**RE: Evans Park PRD, 17909 25<sup>th</sup> Ave NE  
1<sup>st</sup> technical review comment response letter  
Permit #: PA22-003**

Please refer to our responses below which address all review comments received from you via email on April 11, 2022. You will find the markup comments listed in the order that they were written followed by our response in *italics*.

**LANDSCAPE PLAN**

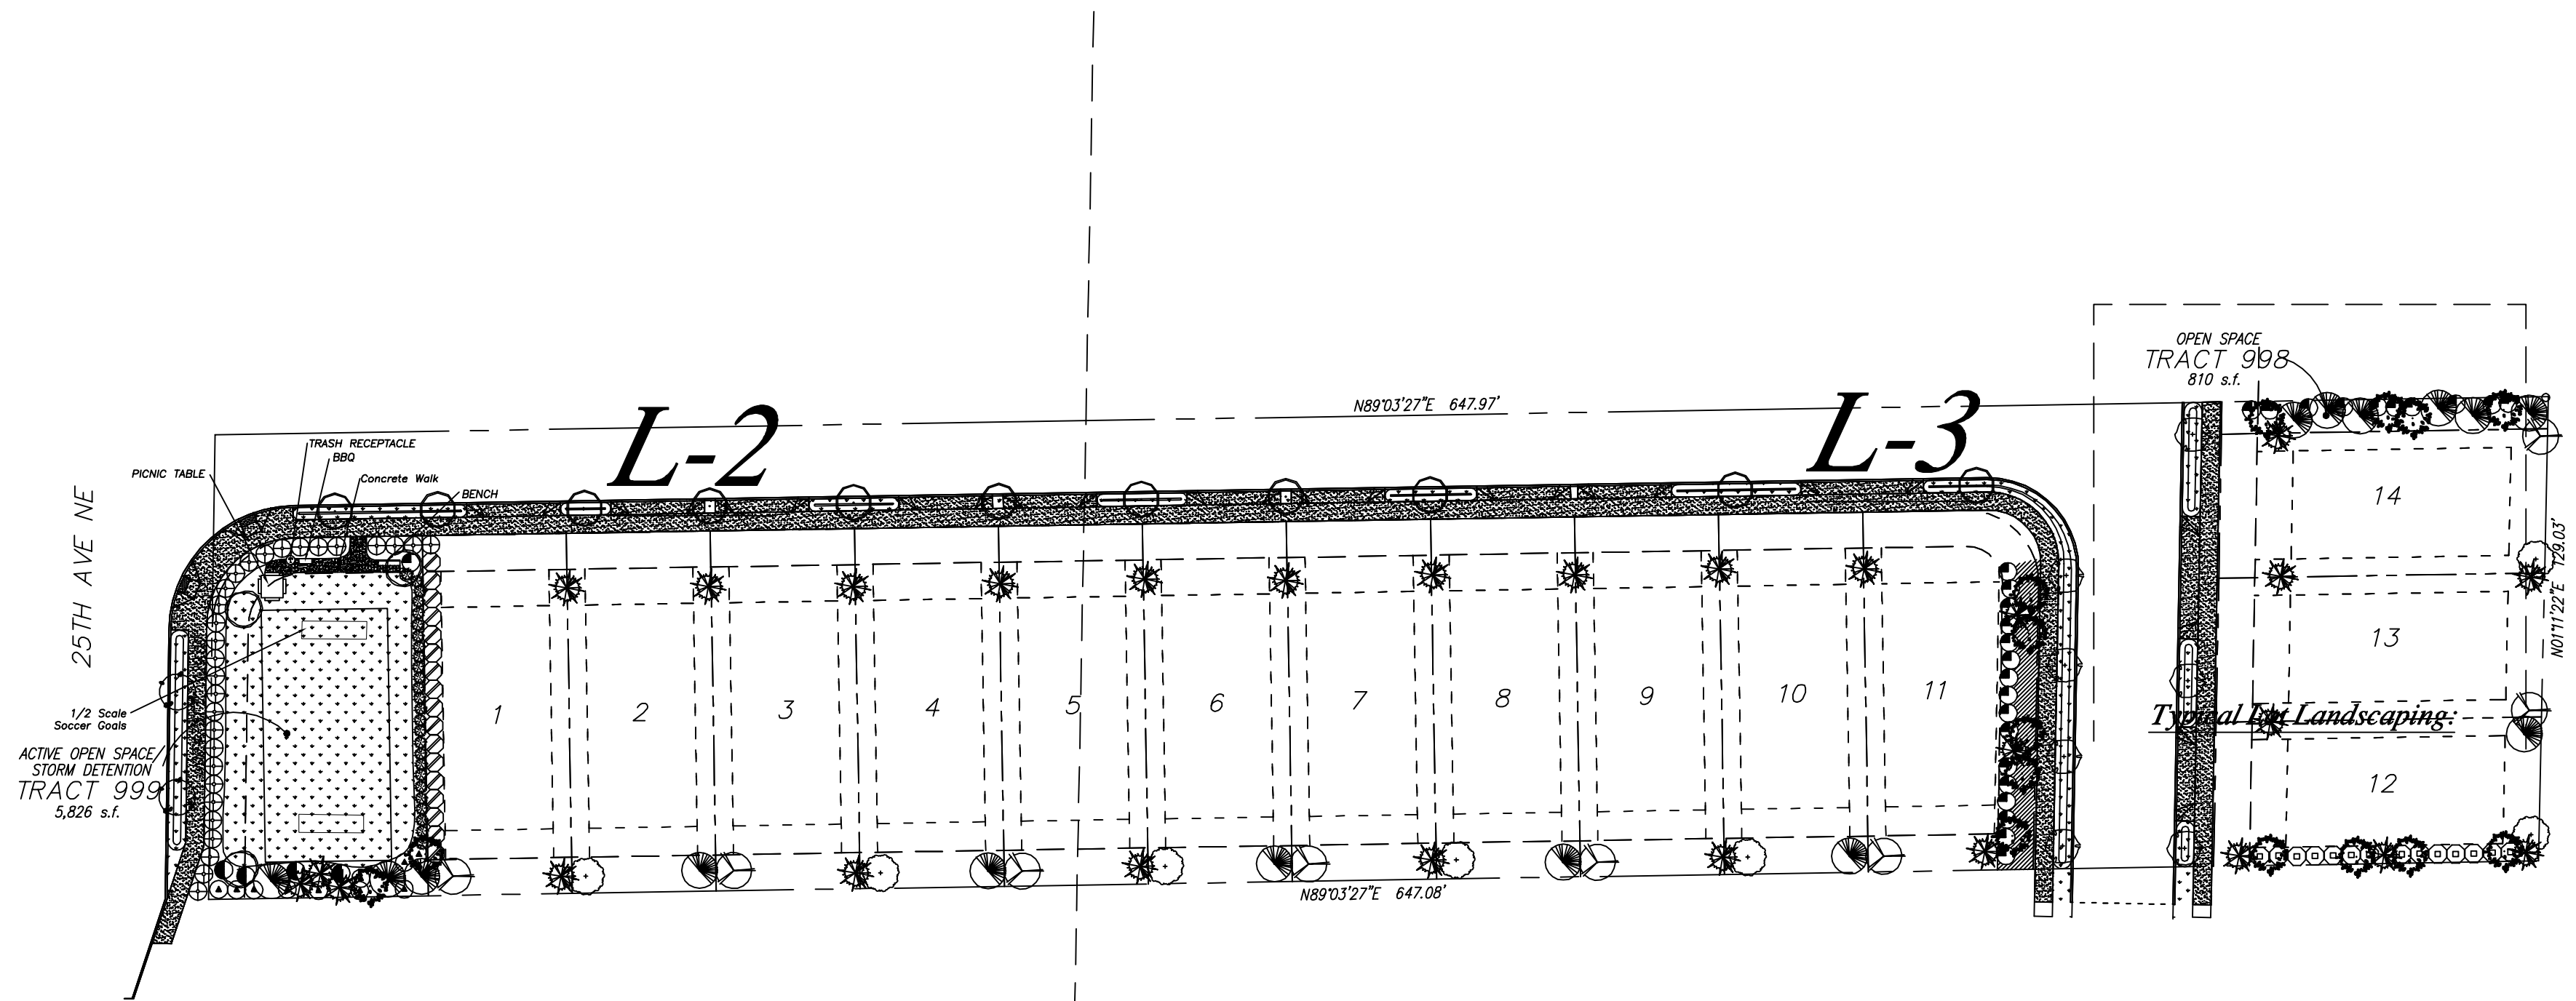
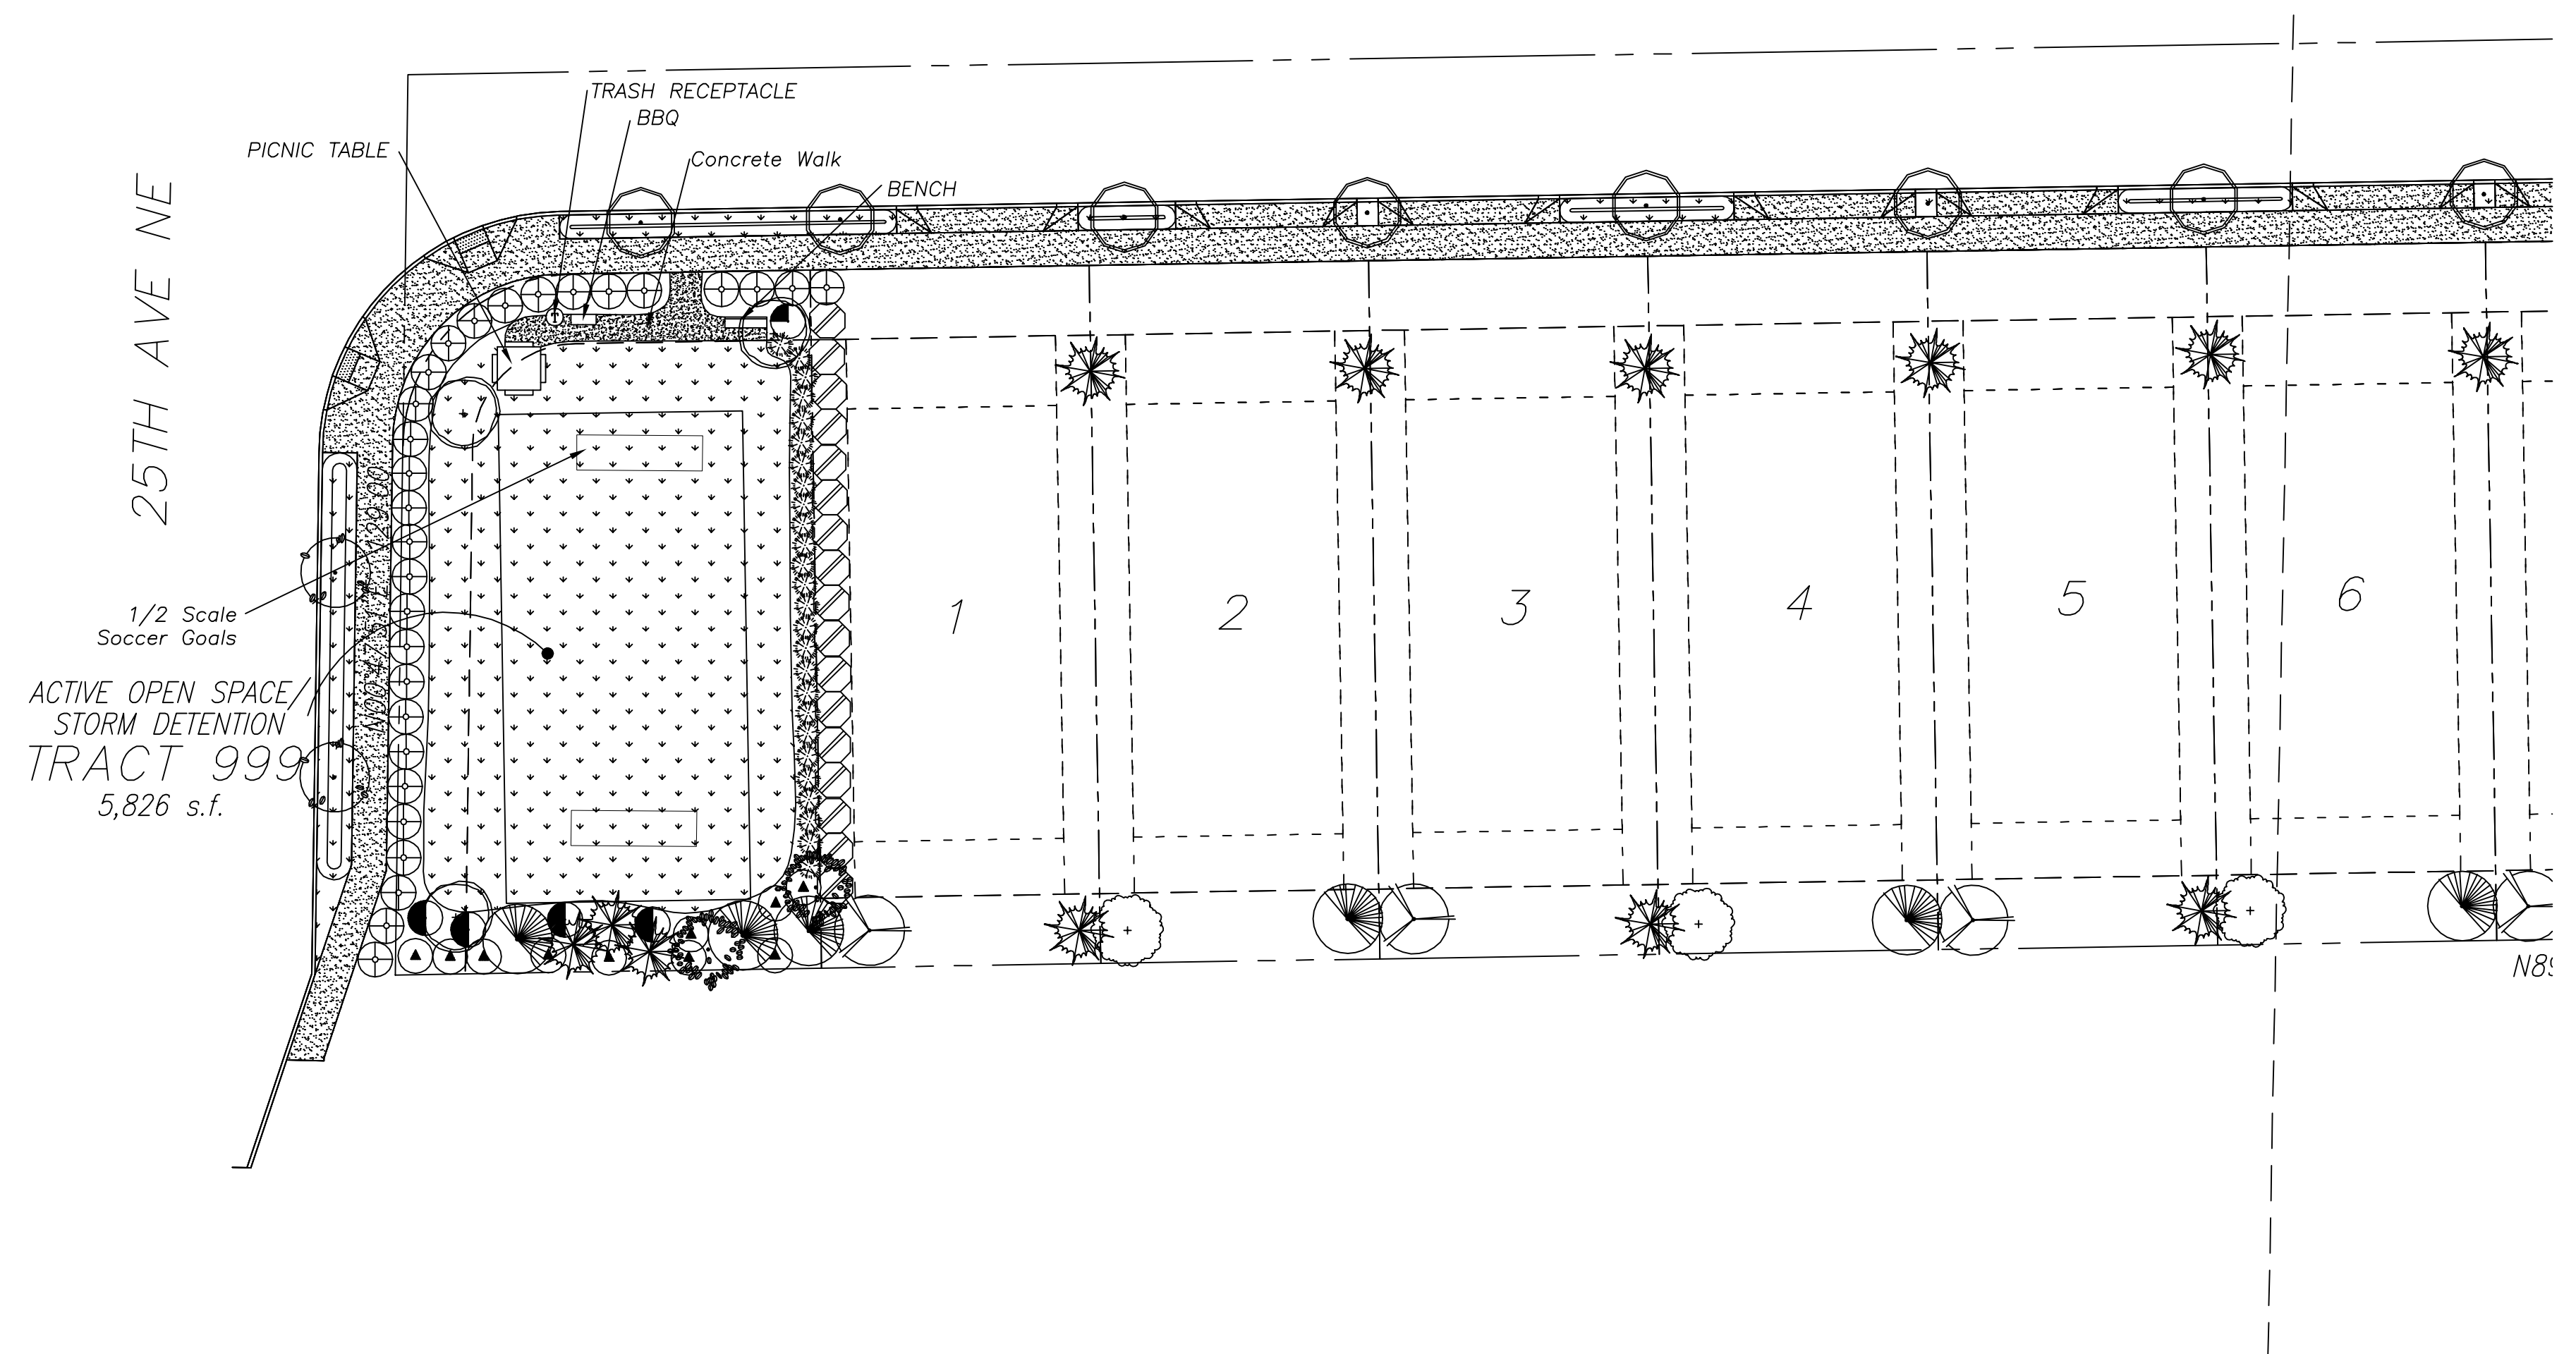
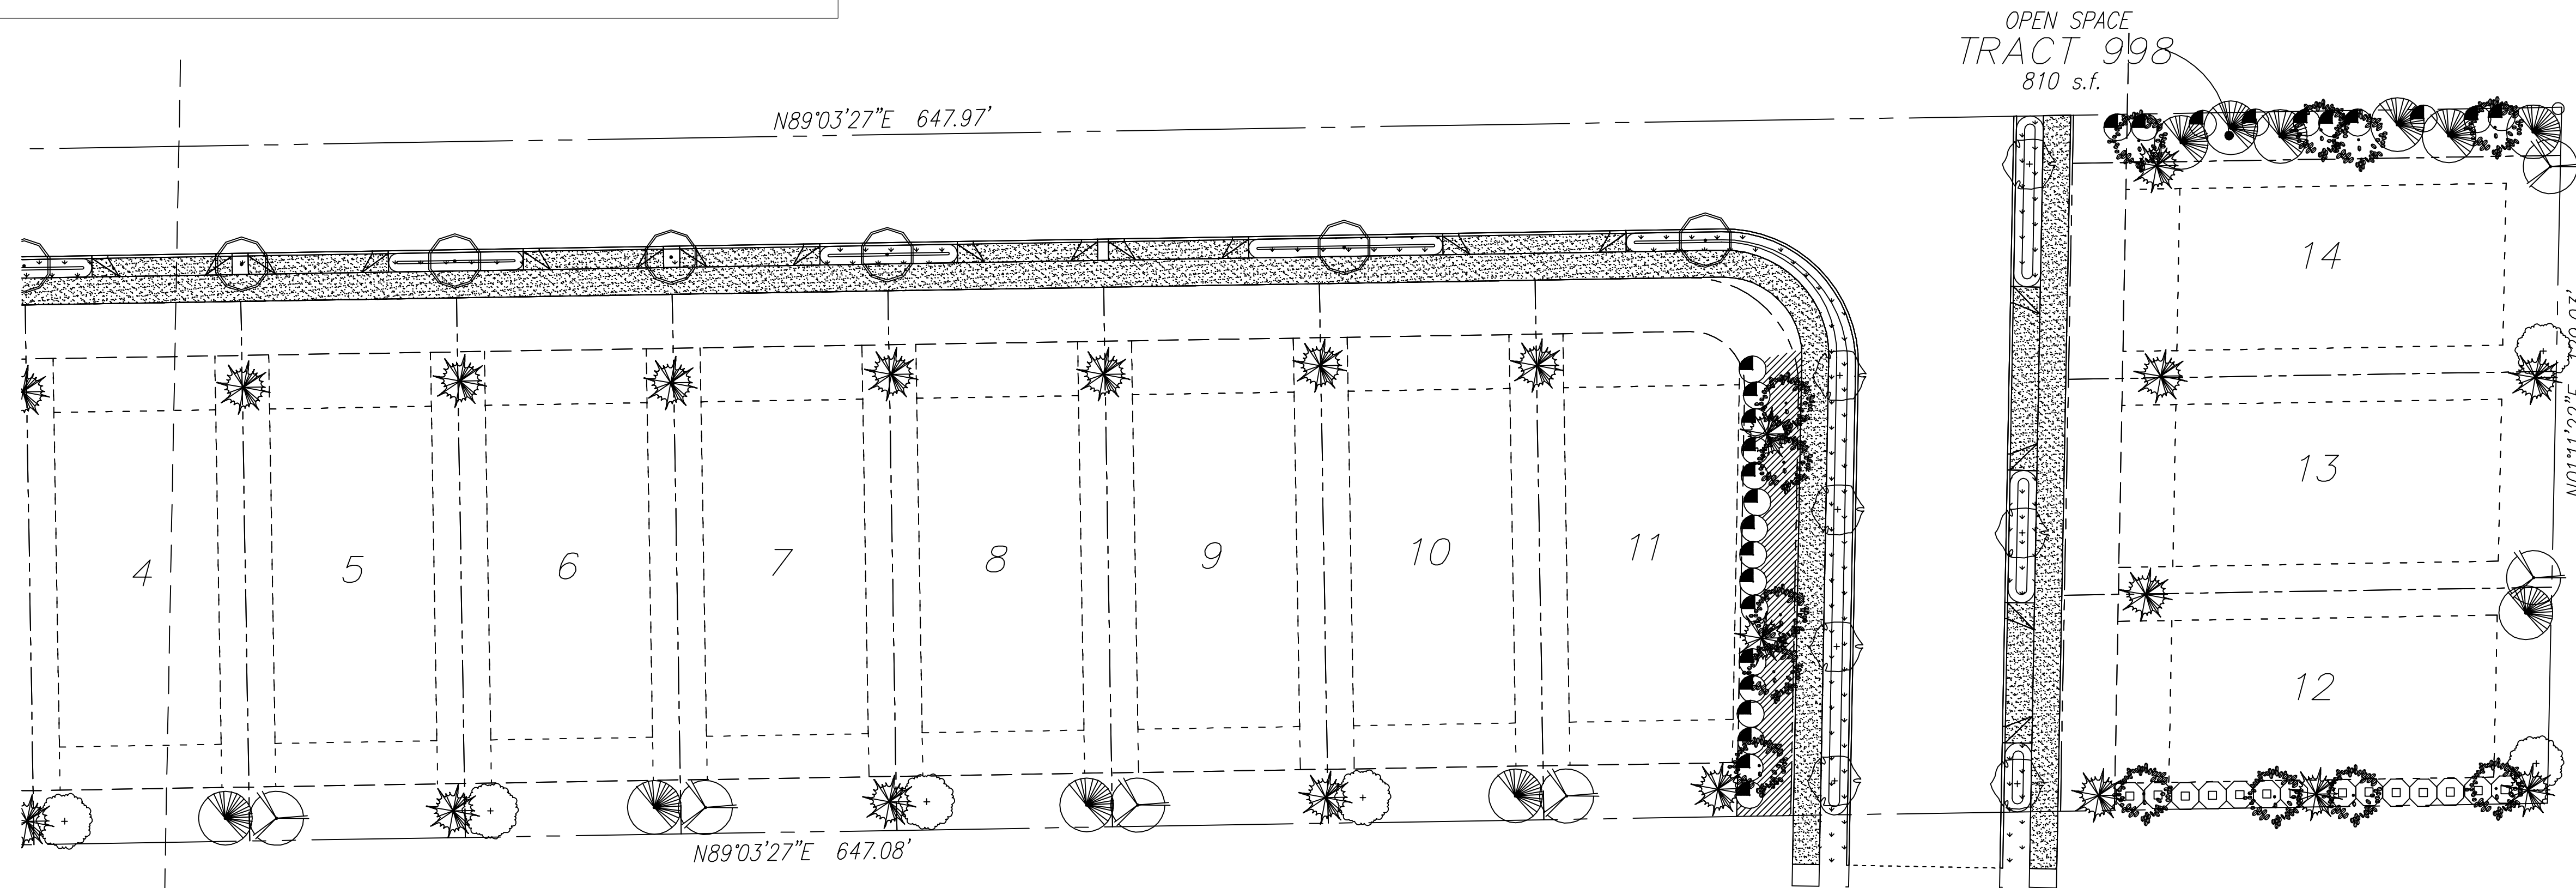
5. The landscape plan shows a different number of lots than the plat map and preliminary civil plans. Please review and revise accordingly.

7. Pursuant to MMC Section 22G.080.100, "Fencing and/or landscaping shall separate, while maintaining visual observability of, recreation areas from public streets, parking areas and driveways." Fencing in compliance with the LNMP standards, or appropriate buffering, shall be installed along the western portion of Tract 999 to ensure that play equipment/users cannot accidentally enter 25th Avenue NE.

8. Please provide details on any trails/paths, surfacing, paving, etc. that is proposed in the open space areas. Trails must be a minimum of five feet wide, meet Americans with Disabilities Act (ADA) standards, and be improved with an appropriate all-weather surface (gravel does not qualify).

4. Please add a detail showing how the bioretention areas will be planted

***Response: Please see the revised landscape plans that are consistent with the revised proposal and updated submittal materials.***

***Response: Please see the revised landscape plans.***

***Response: Please see the revised landscape plans.***

***Response: The bioretention area is to be planted with microclover per callouts and schedule found on the revised landscape plans. No detail was provided but clarity was given to the legend and schedule to depict this.***
